Application No: FG/46/21/PL
Site Address: Land between 11a The Grove and 30 Brook Lane Ferring
Description of works: Development of 1 no. 2 bed house set over 2 floors, with first floor being partially contained within roof, along with associated parking & amenity spaces. This site is within CIL Zone 4 and is CIL liable as new dwelling.

Thank you for your internet representation made on 22nd April 2021 which has been recorded as an objection with the comments as follows:

Drawing Title 028_07 Proposed West & South Elevations Land between 11A The Grove and 30 Brook Lane, Ferring	
Completion date 17/03/2021	
Drawn by Guy Rochez	
Scale: 1:100@A3	
Print Size: A3	
Notes:

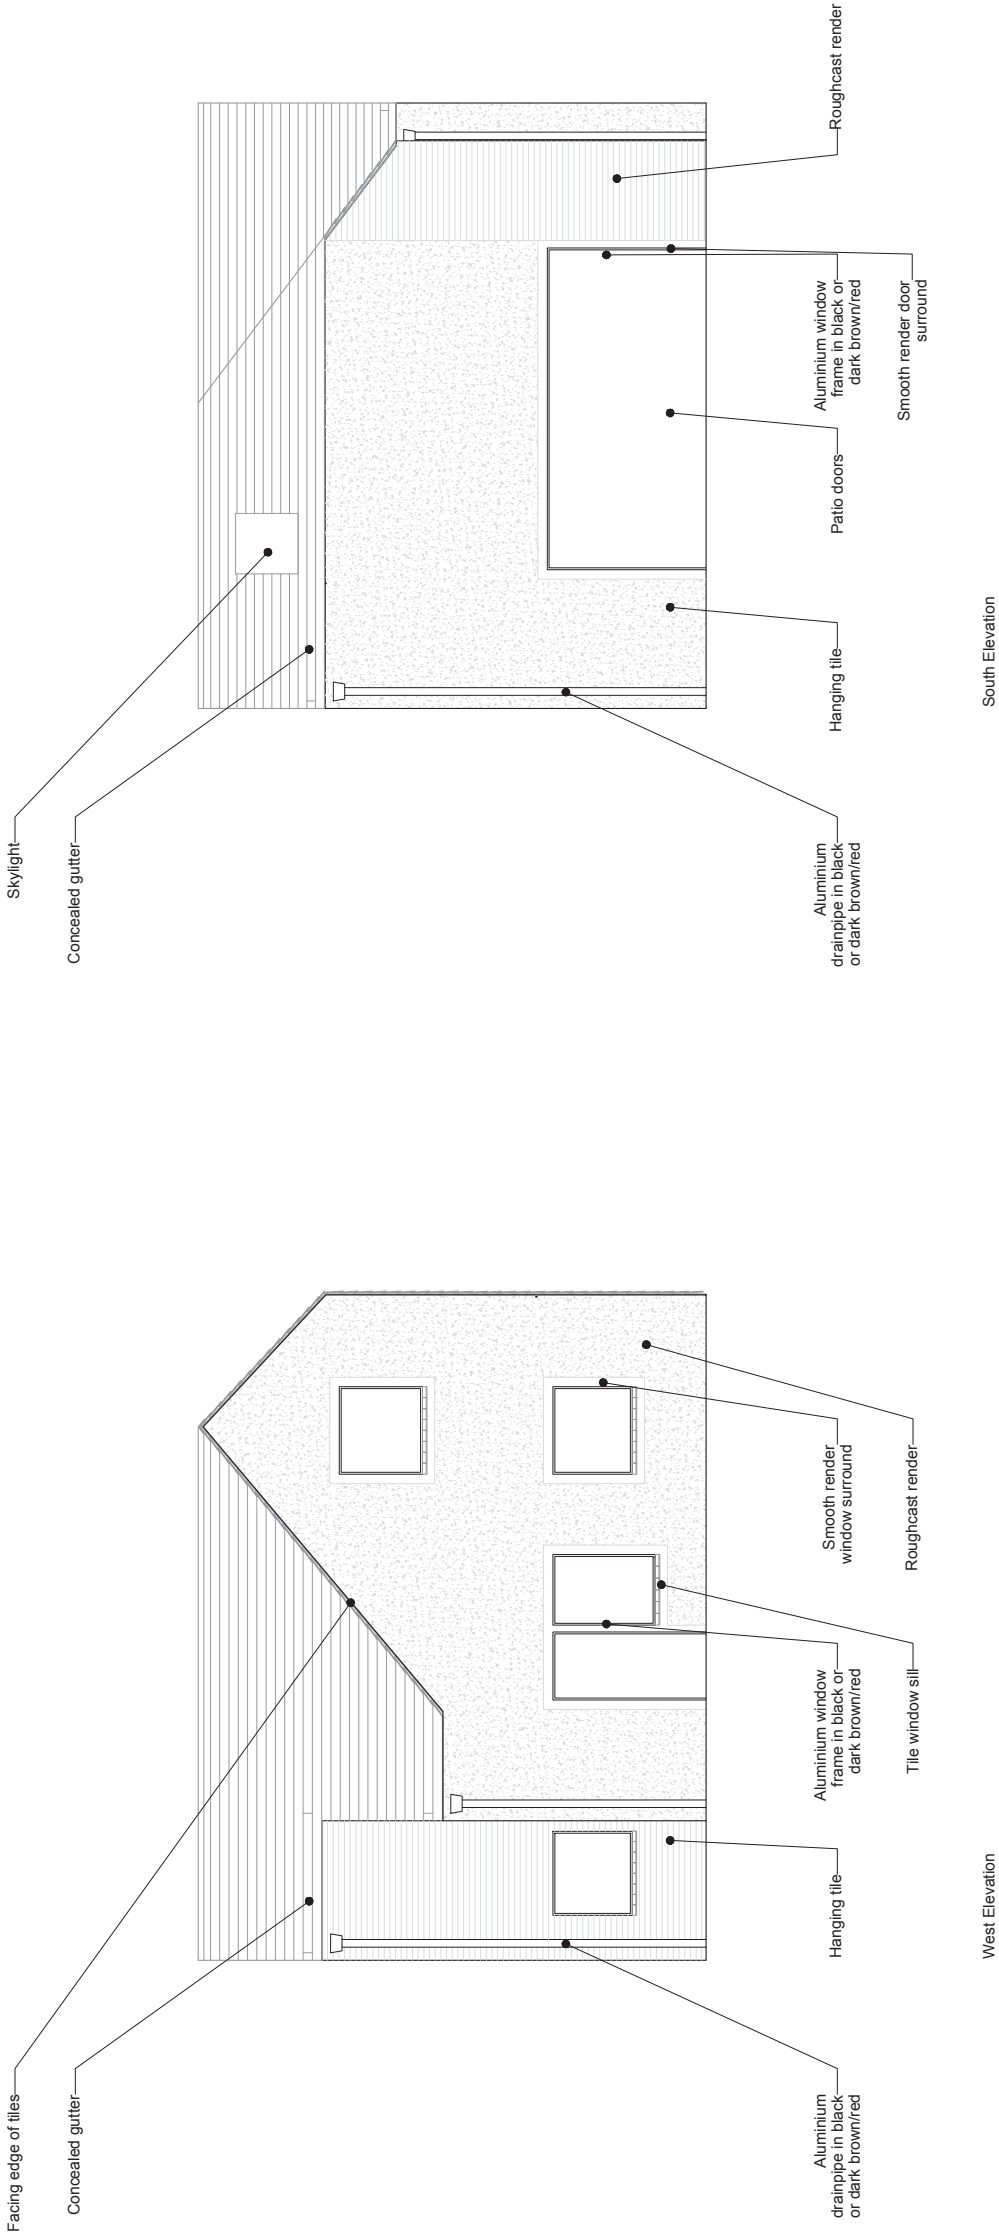
The house is far to big for the plot. It will overlook and overshadow the neighbouring house. The outdoor space is much too small for a 2 bed house. As I'm in the building trade I can say rear elevation is too close to the boundary wall, less than 25 cm in places and it cannot be built, or rendered or maintained without entering and trespassing in the neighbours garden. Future maintenance required will be a recipe for ongoing disputes.
